## Silvertown Tunnel Development Consent Order

### London Borough of Hackney

# Update and comments on the updated draft Development Consent Order

<b>PINS Reference</b>		
<b>Document Number</b>	LBH 09	
<b>Authors</b>	LB Hackney, Project Centre, GVA	
<b>Revision</b>	<b>Date</b>	<b>Description</b>
0	March 2017	Deadline 4 Version

Figure A - 1: ATC sites in the Area of Influence

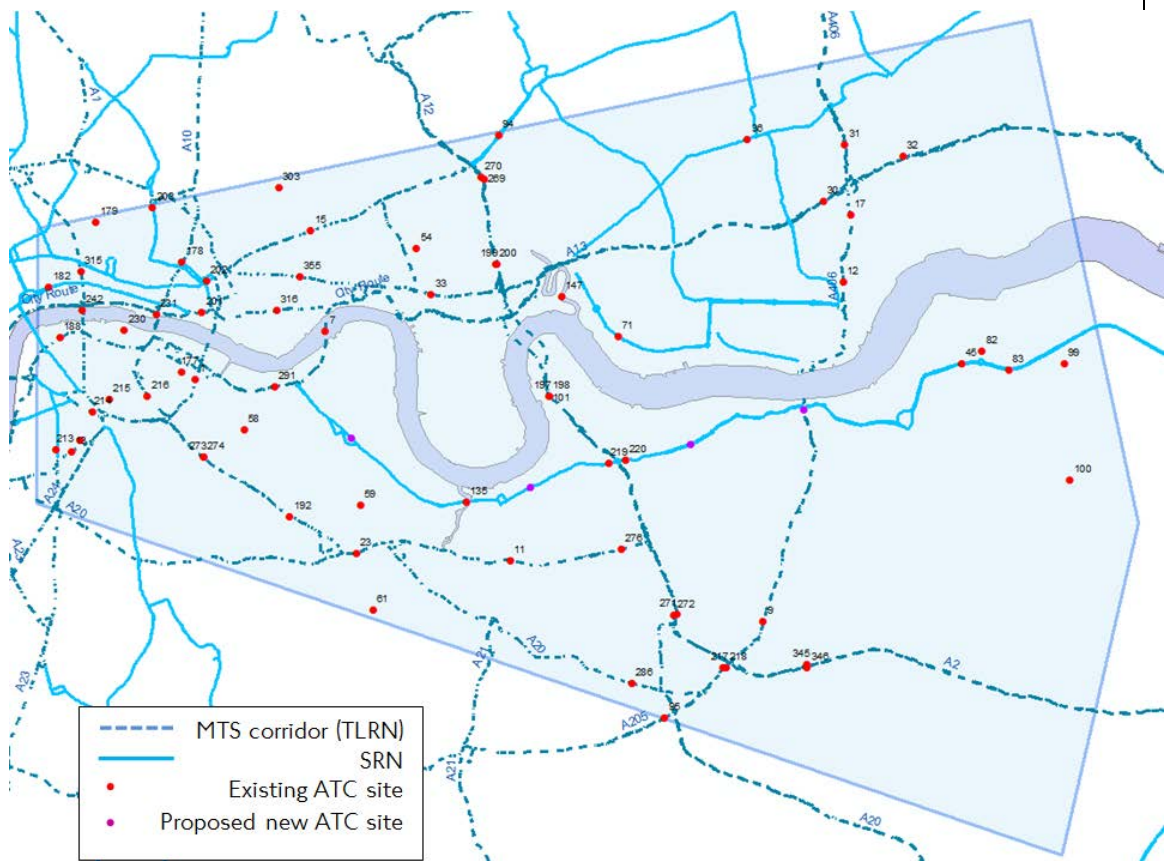
Paragraph 3.11.2 sets out how any STIG members can request changes to the monitoring to enable the impacts of the scheme to be fully captured. Throughout the consultation LB Hackney have identified areas that require monitoring but these have not made it in to the current draft as set out below. This lack of willingness from TfL at this stage give no confidence for future changes to the monitoring in future as suggested in the latest draft.

The traffic and air quality monitoring proposed within the borough does not include key links identified by the Borough throughout the process, at the January ISH's and the oral submission. These are the key links to the A12 and will be affected if additional traffic is drawn to the new tunnel, these are; Wick Road, Kenworthy Road, Cassland Road and Victoria Park Road as well as the A12 in the borough.

It is stated that the triggers will cover the 'Area of Influence' (AOI) but does not include a figure to illustrate this area. It was previously highlighted by the borough that the AOI had changed between recent documents so it is unclear what the current AOI covers. The coverage of the AOI was also contested as not extending far enough to the north. Concern remains that the monitoring does not extend far enough away from the scheme.

In addition we are also now proposing to undertake annual traffic counts at the four locations requested in Hackney (Cassland Road, Wick Road, Victoria Park Road and Kenworthy Road) as part of the monitoring programme
